Re: Planning Application 19/0566

Address: 25 Greenacres, Read Burnley BB12 7PT

Description: Two story extension to side with excavated garden banking to increase parking.

Proposed Details of a Side Extension to 25 Greenacres, Read, Lancs

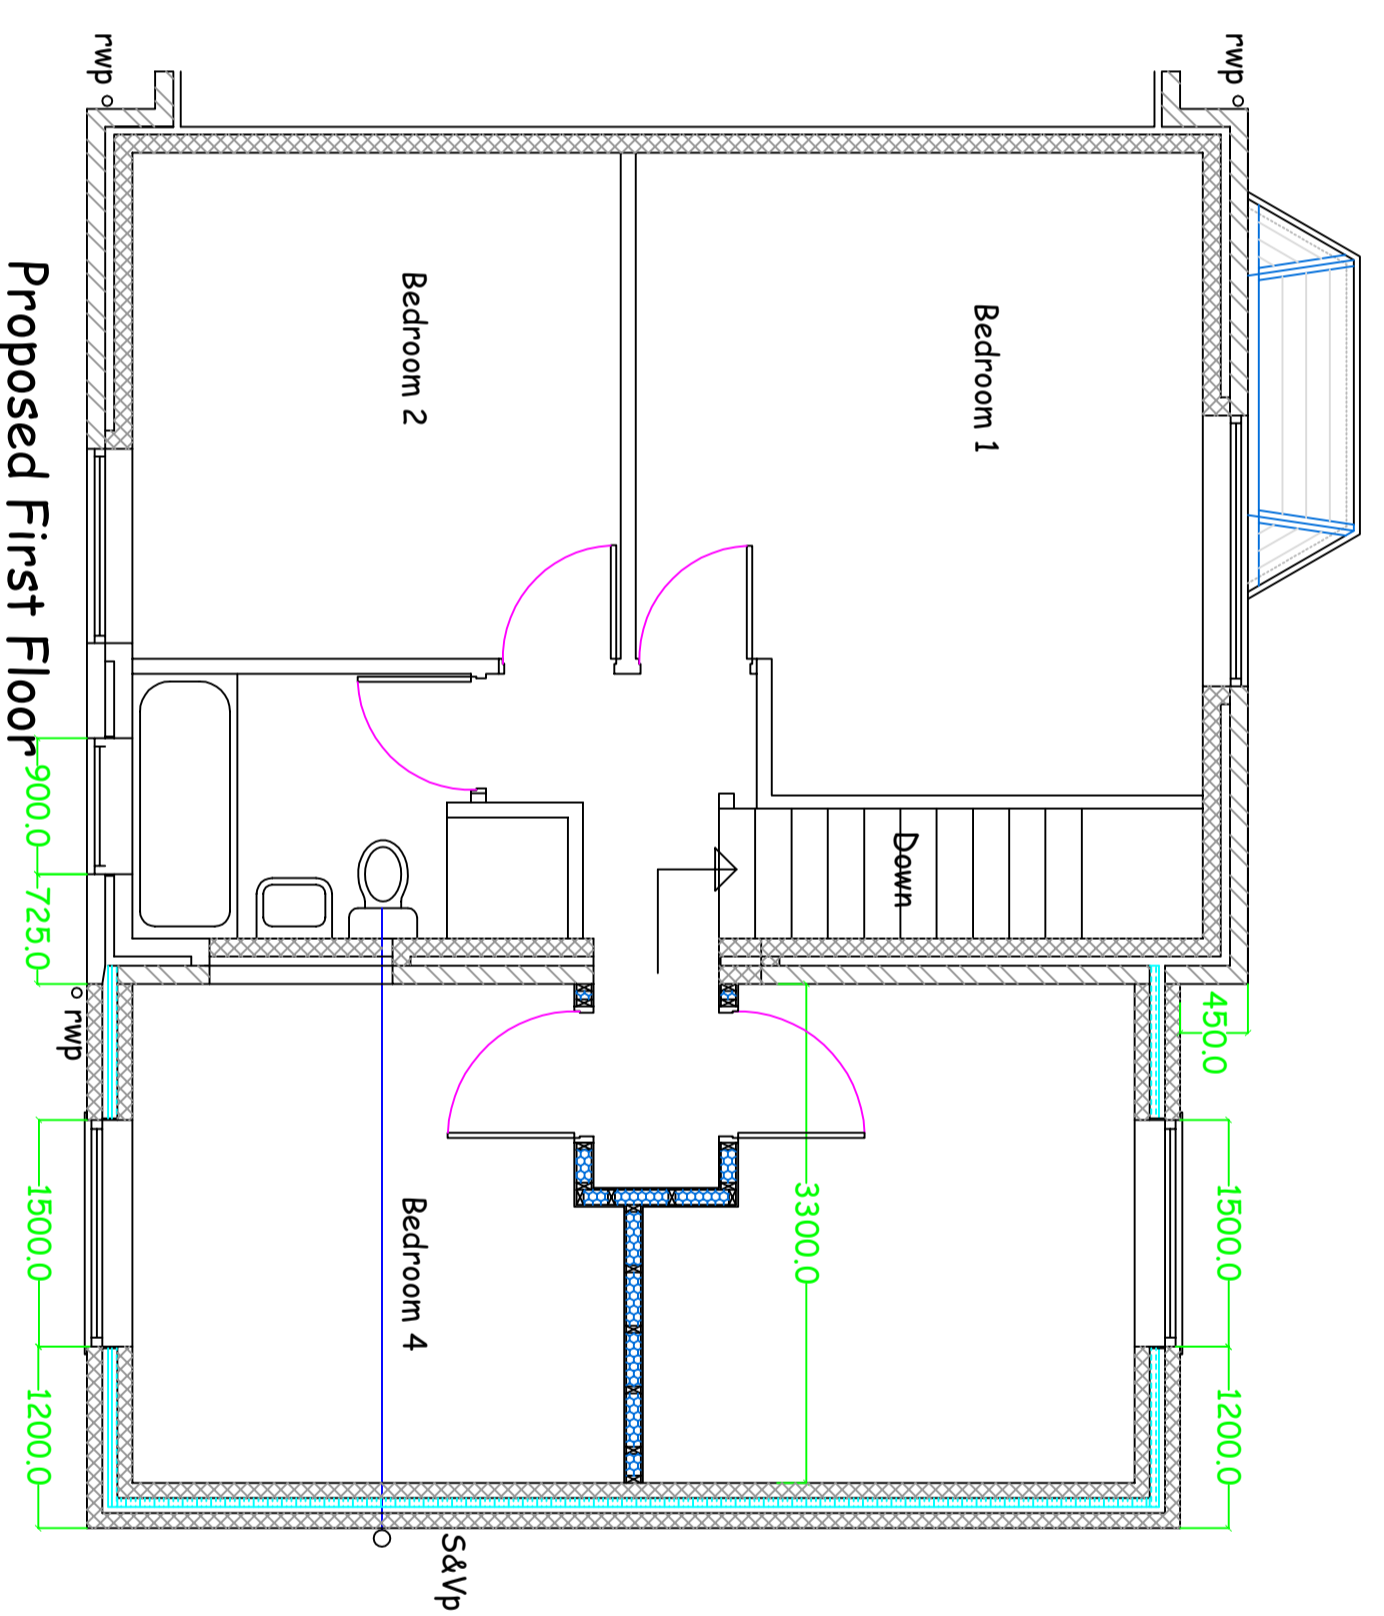
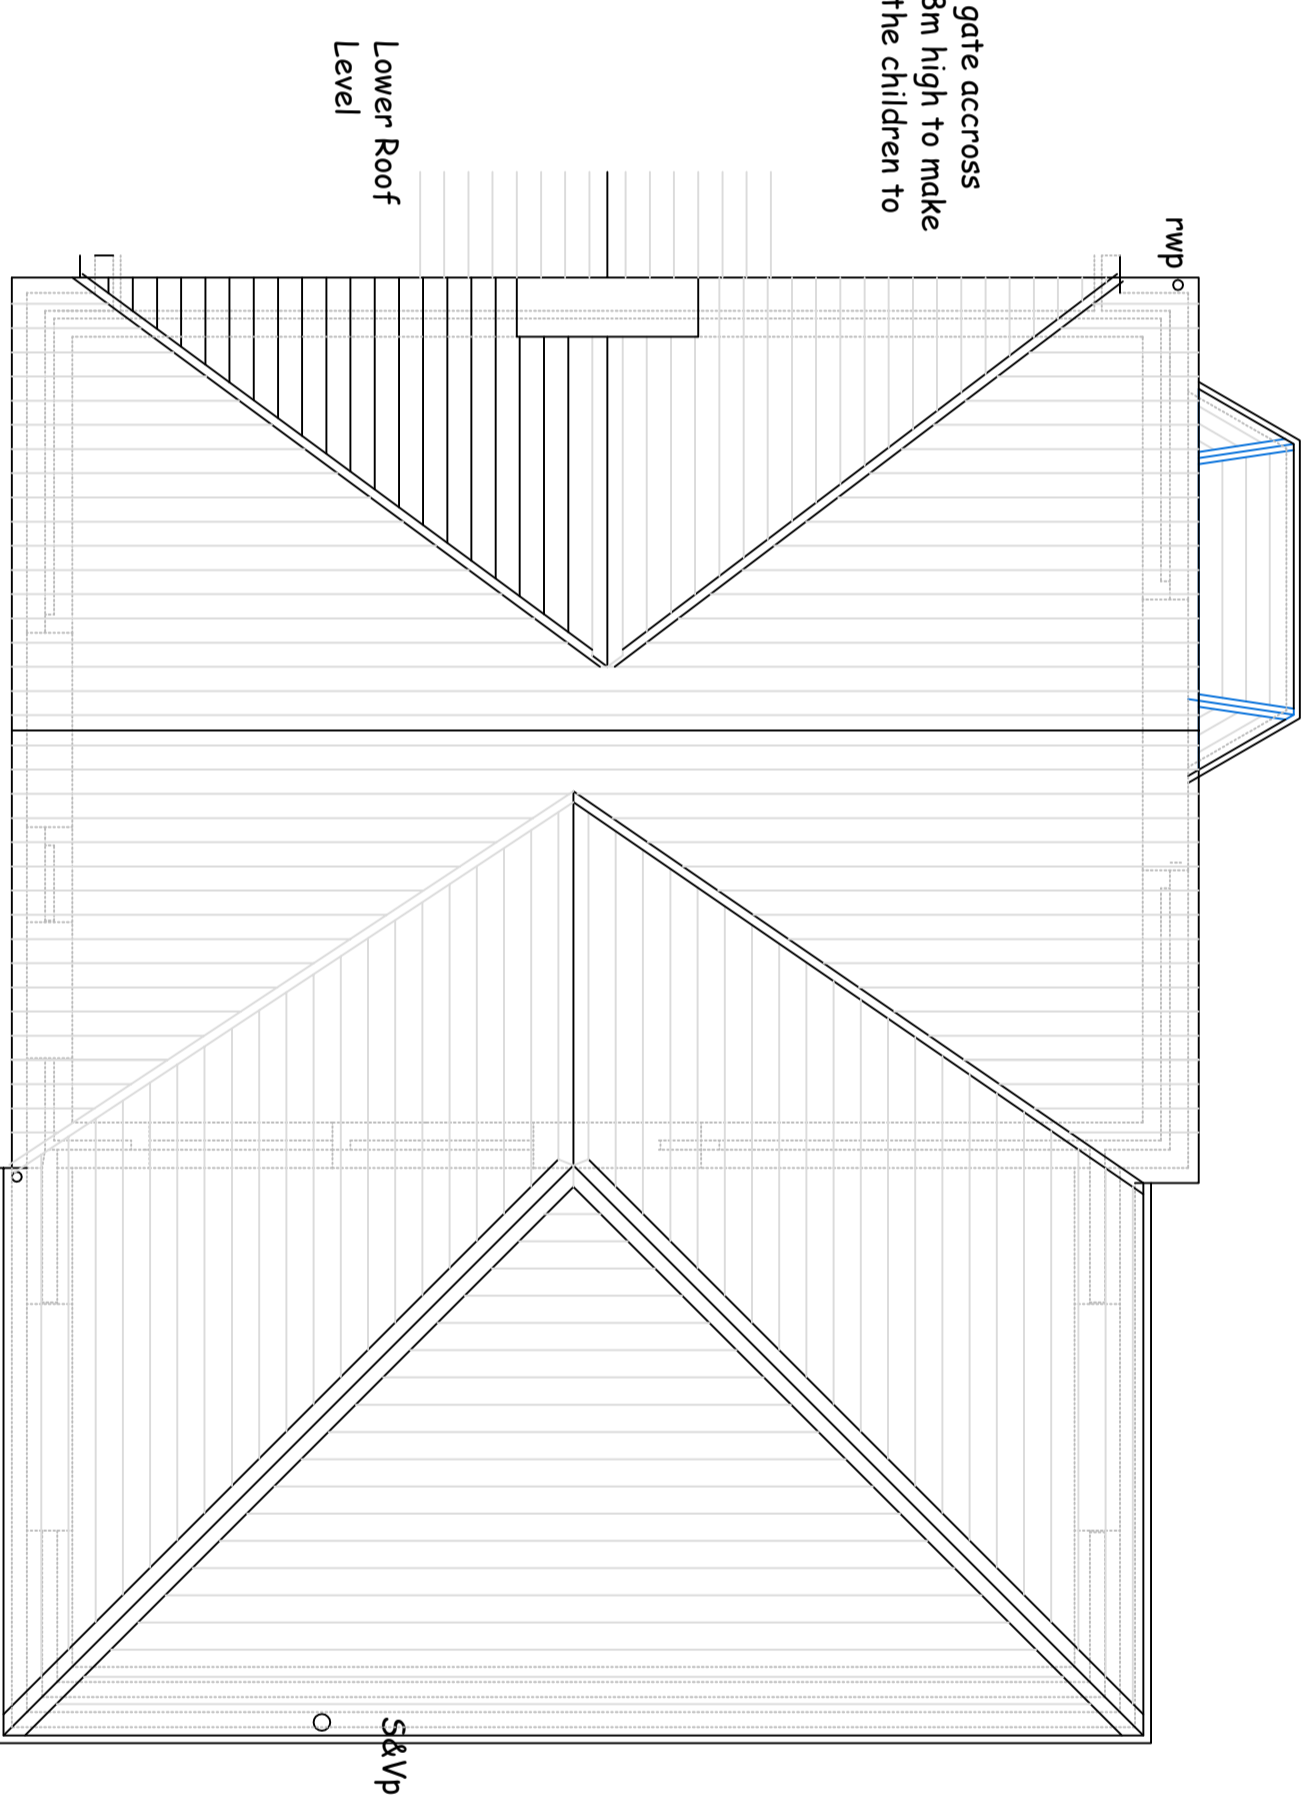
It is noted that there is proposed to be an increase in the bedrooms from 2 to 4 bedrooms. Applying Lancashire's Parking Standards this type of property should be provided with 3 car parking spaces.

Two spaces have been provided to the minimum size of 2.4m x 5m, although the recommended minimum clear width of 3.0m where the private drives are sandwiched between walls and fences to allow room for the doors to open has not been achieved. Additionally the third space shown on the amended plan impedes access to the front door for both residents and deliveries such as a post man and does not achieve the recommended length.

It is felt that should the occupants of the dwelling have access to three vehicles then the three spaces will not be utilised and the remaining vehicle will need to be parked on the highway which will narrow the road and create an obstruction adjacent to the School Keep Clear markings.
